BN/21/22/PL

The Hollies 84 Barnham Road Eastergate PO22 0ES

Demolition of existing care home and construction of 5 no. dwellings and garaging, with landscaping and associated works. This application affects the setting of a listed building

Studio Lack Architecture		84 Barnham Road, Barnham.	Elevations Plot 1	Dwg 2123-18
Studio Lack Ltd : 17 Beech Avenue : Chichester			01/02/22	
01243 782 886 : nicholas.lack@live.com : PO19 3DR			1/100 @ A3

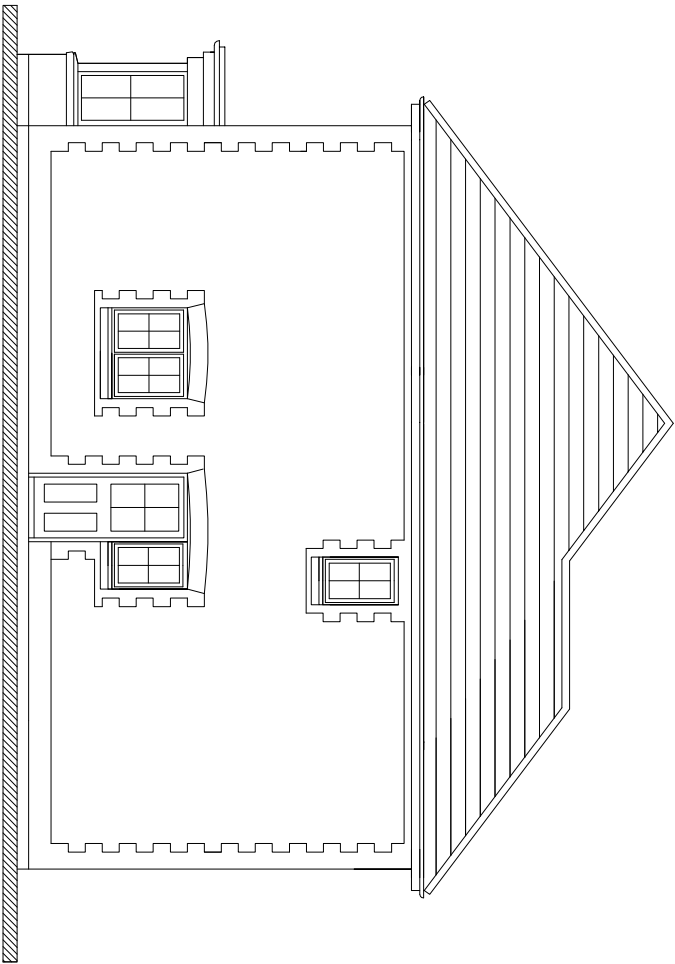
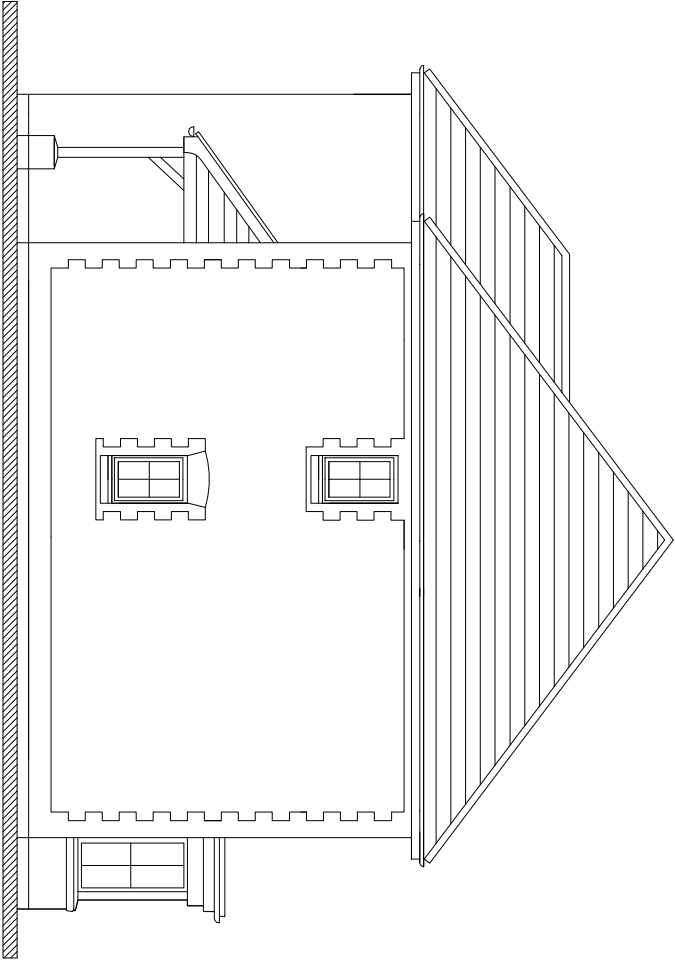
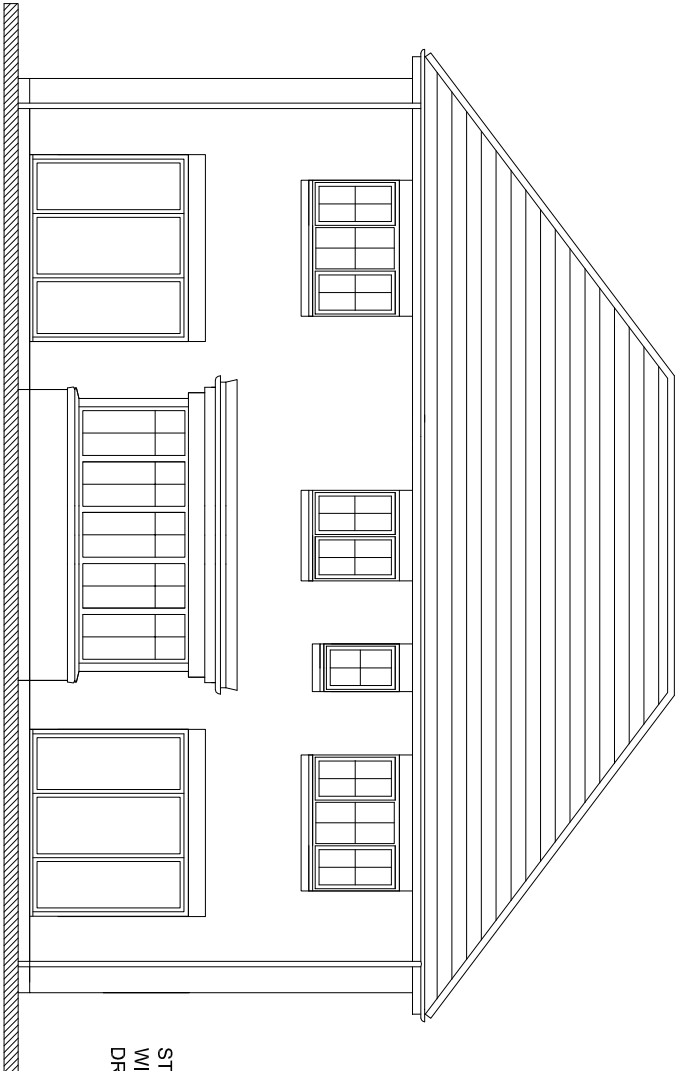
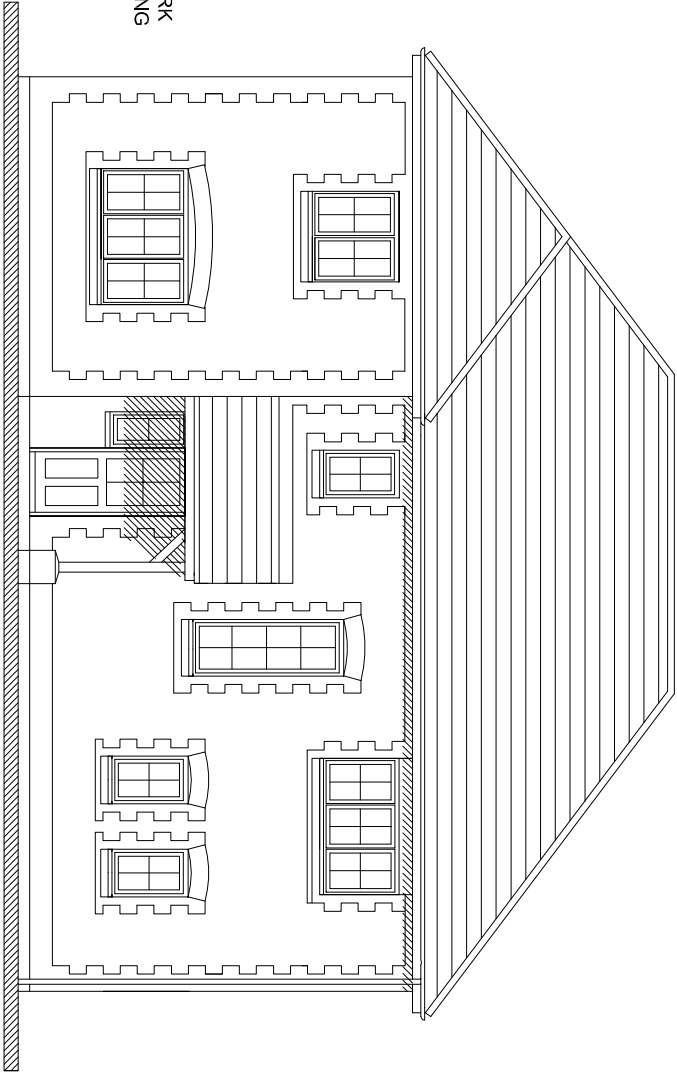
It would appear that the new homes are of a fairly standard design for the local area and found in other new/recent developments. Their success will be down to the use of high quality, traditional materials as opposed to standard, modern ones. Further, it is suggested that smaller design features such as recessing the windows to create a shadow line and carefully considered eaves details will also enhance the more standard appearance.
